**Re: McMahon Commons at 6530 McMahon Blvd. NW
Erosion and Sediment Control Plan
Engineer's Stamp Date 5/10/24 (A10E002G)**

Based on the information in your submittal, received on 5/15/24, the above-referenced ESC Plan cannot be approved until the following comments are addressed.

ESC-1

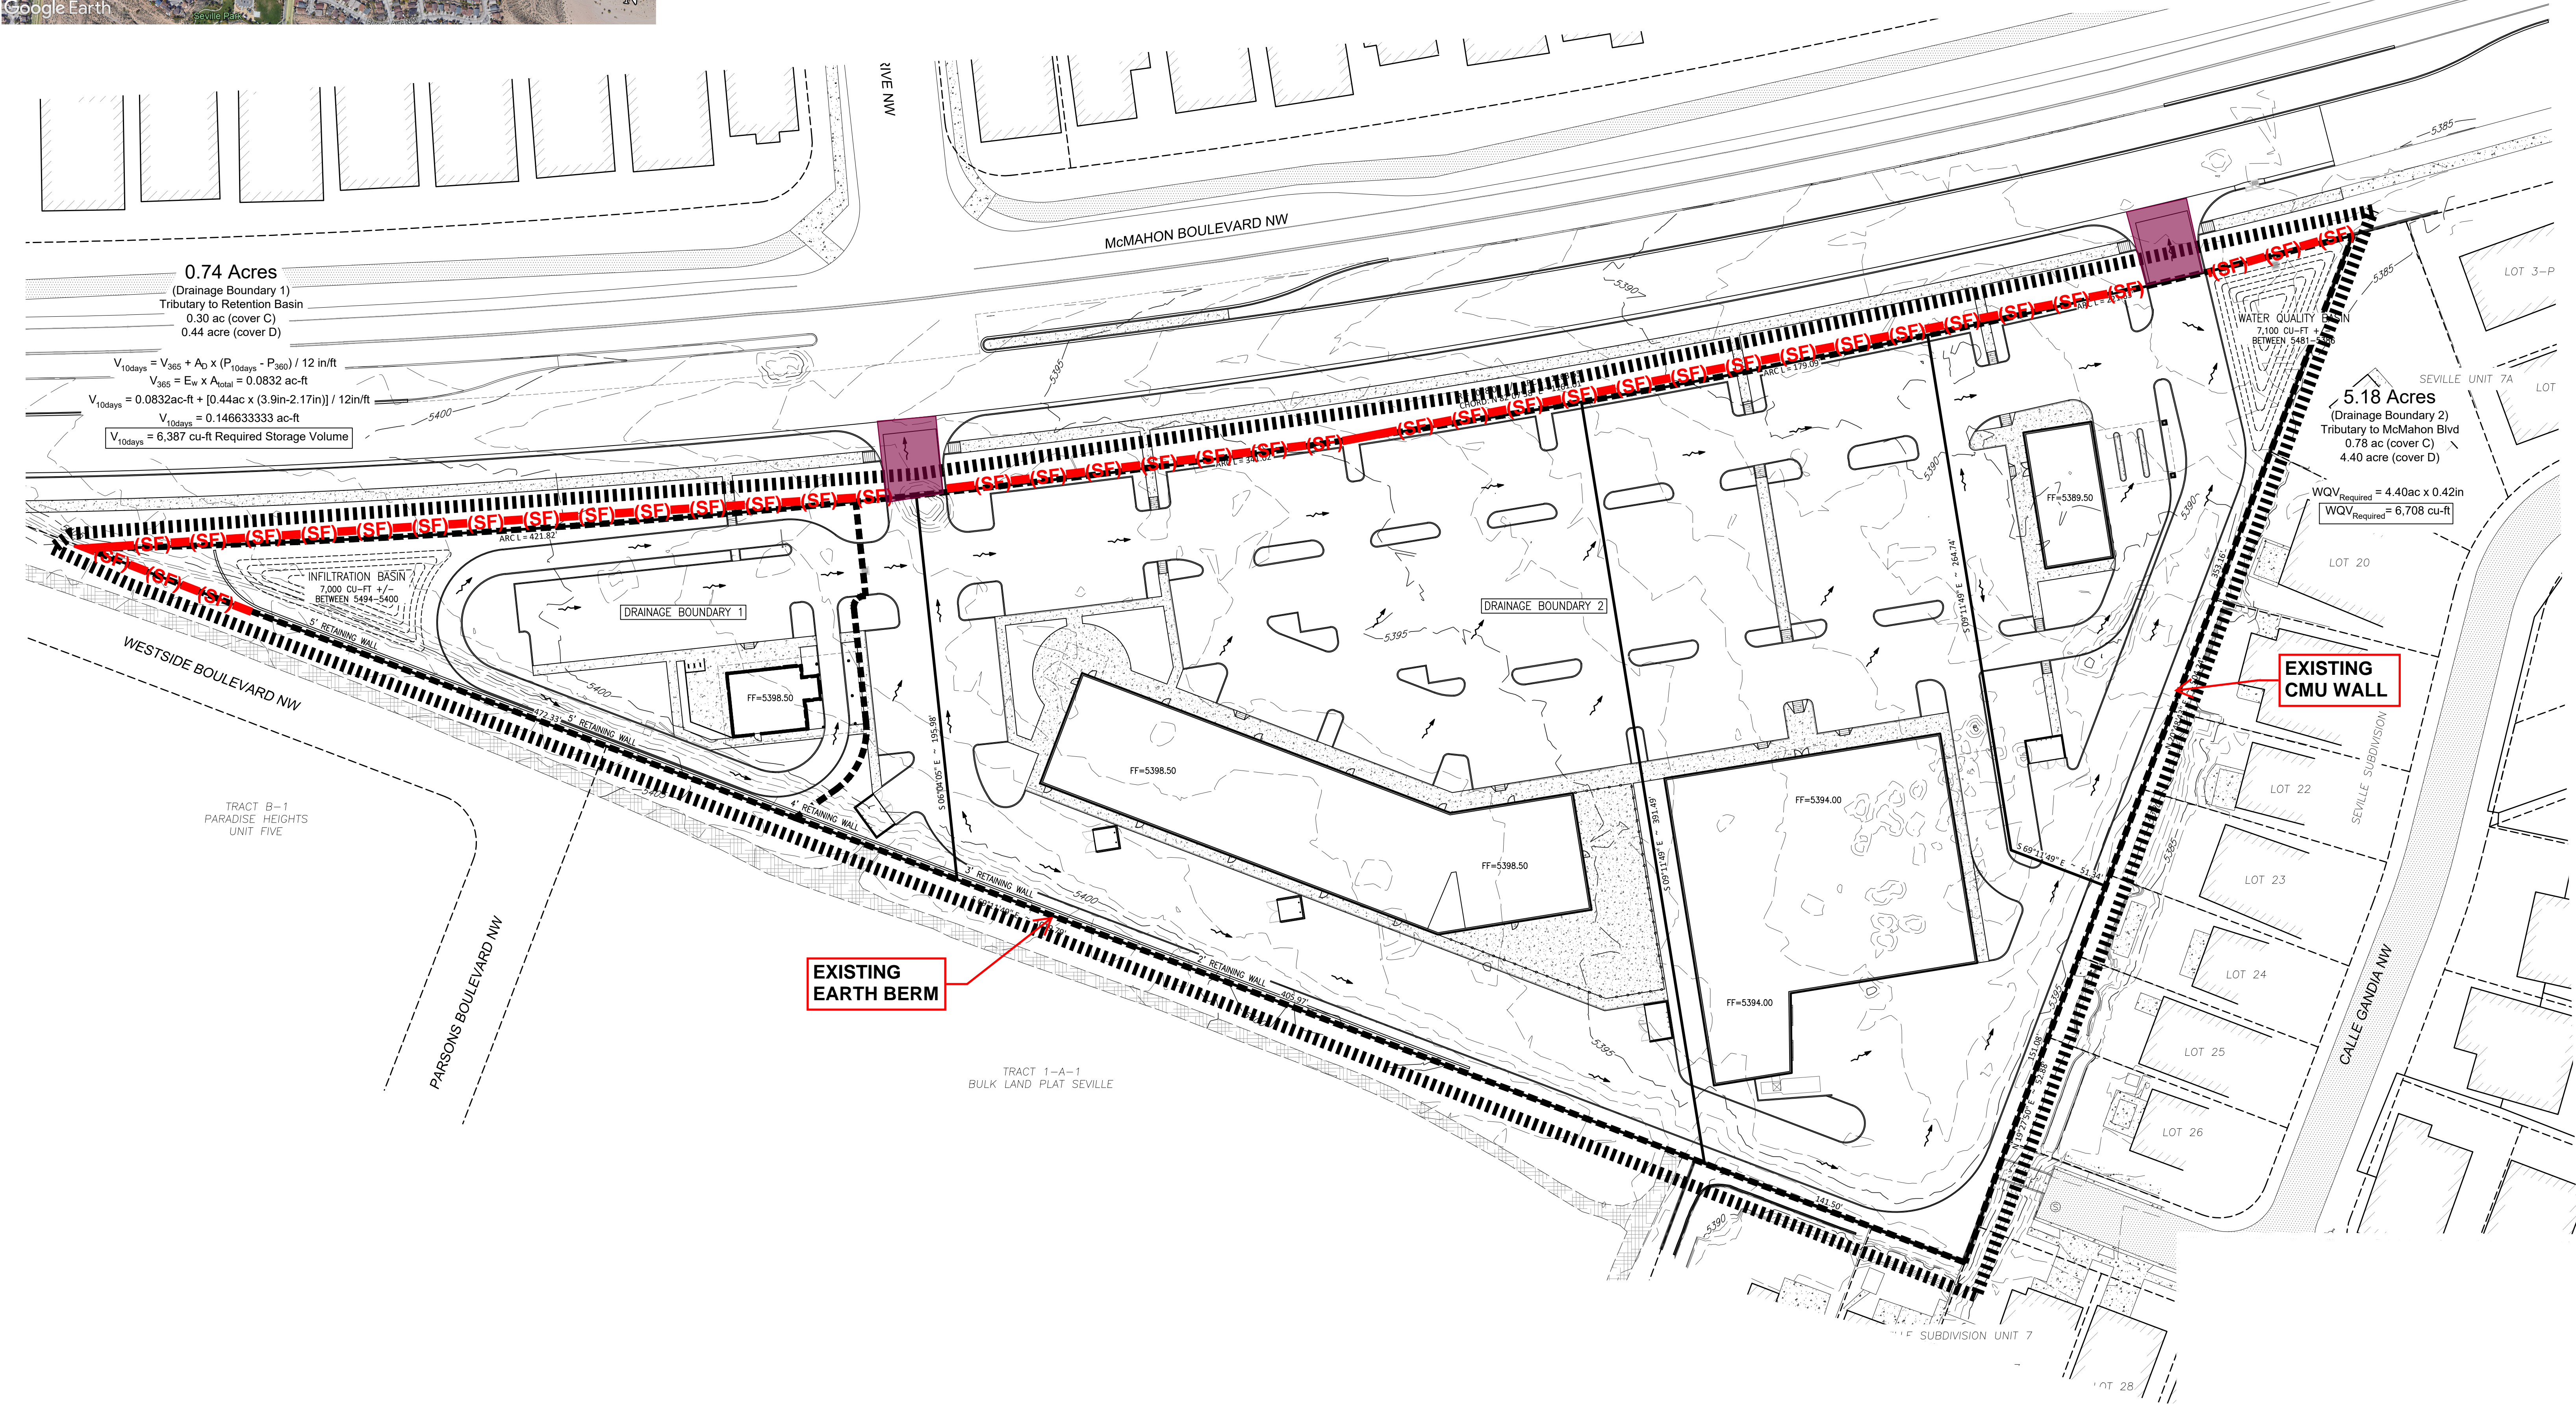
1. The ESC Plan can't be approved until after Hydrology approves the G&D Plan for each specific purpose, Site Plan, Grading, Building Permit, and Work Order. Hydrology has not even received a submittal. The proposed grades are missing. The existing and proposed grades must be shown on the ESC Plan, and they must agree with the Grading Plan approved by Hydrology (CGP7.2.4.b.ii);

2. The limits of disturbance must include the disturbed portion of the public right of way next to the property. (CGP7.2.4.b.i).
3. The estimated area of disturbance, including disturbed frontage, is about 8 acres.

4. You must design and install all stormwater controls in accordance with good engineering practices, including applicable design specifications per CGP 2.1.2. The City ESC Plan Checklist requires berms and a sediment basin per CGP 2.2.12. at the downstream end of the site. CGP 2.2.12 requires temporary retention of the 2-yr 24-hr runoff volume or 3600 cf/acre from the area that drains to them, all of the areas, not just the onsite disturbed portion of the drainage area. Hydrology calculations should anticipate about 50% impervious cover during construction when determining the design volume. Sediment Basins must be designed and stamped by a registered Professional Engineer (PE.) Limit construction ingress and egress to the high side of the site, the west end, to prevent a breach in the controls placed at the downstream end.

5. The SWPPP must include site-specific interim and permanent stabilization per CGP 9.6.1.c.i. The Landscape Plan and Work Order sheets can be used to satisfy this requirement and should be submitted separate from the ESC Plan with the application to the Stormwater Quality Section of the Planning Department and they should be included in the SWPPP. Provide a specification on the ESC Plan for any disturbed areas not covered by the Landscape Plan or Work Order sheets.

6. Update the engineer's stamp date each time the plan is changed.
